My ref: DC/AC/2008/1459

RE: Erection of a pair of semi detached properties, on land to the rear of New Street

I refer to the above planning application, which is a resubmission following a previous outline approval.

PROPOSED PAIR OF SEMI-
DETACHED DWELLINGS ON
LAND REAR OF NO 10 NEW
STREET, WORSBROUGH DALE
FOR MR. B. JONES.

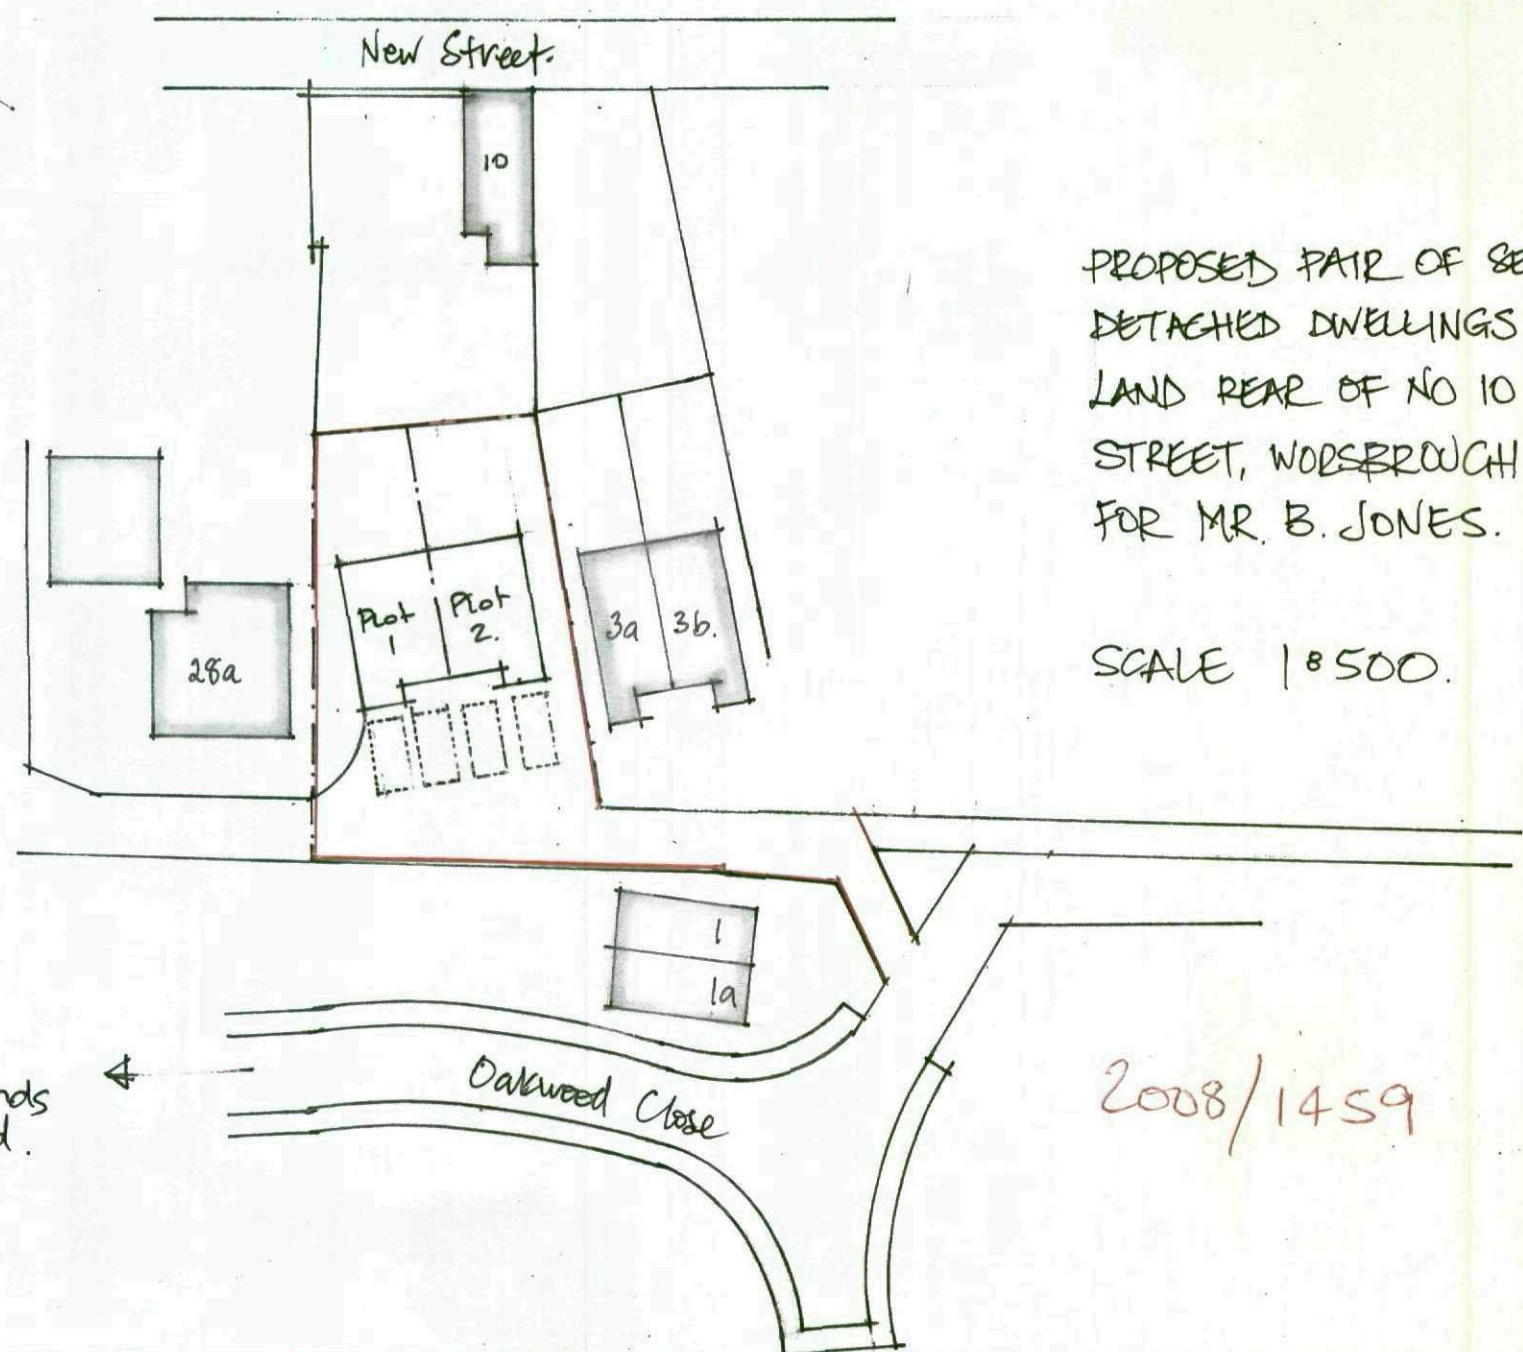
Because of a change in circumstances since the original approval was granted, I am now unable to fully assess whether or not the development is acceptable without further information. The change in circumstances to which I refer relates to the status of the access road, known previously as Goose Hull Road. When the original outline approval was granted it was envisaged that access to the site would be via this road. However as this road has been significantly narrowed, it is now impossible to pass by car. Access to the site, for vehicular traffic, can now only be via Oakwood Close.

In light of the above I require an amended red line boundary, showing the site and its junction with Oakwood Close. I also of the proposed layout as this needs to include an area for the parking and turning of vehicles. To fit this on the dwellings proposed need to have a smaller footprint and be sited more centrally. Please submit the above within the next 14 days, otherwise a decision will have to be made on the current scheme.
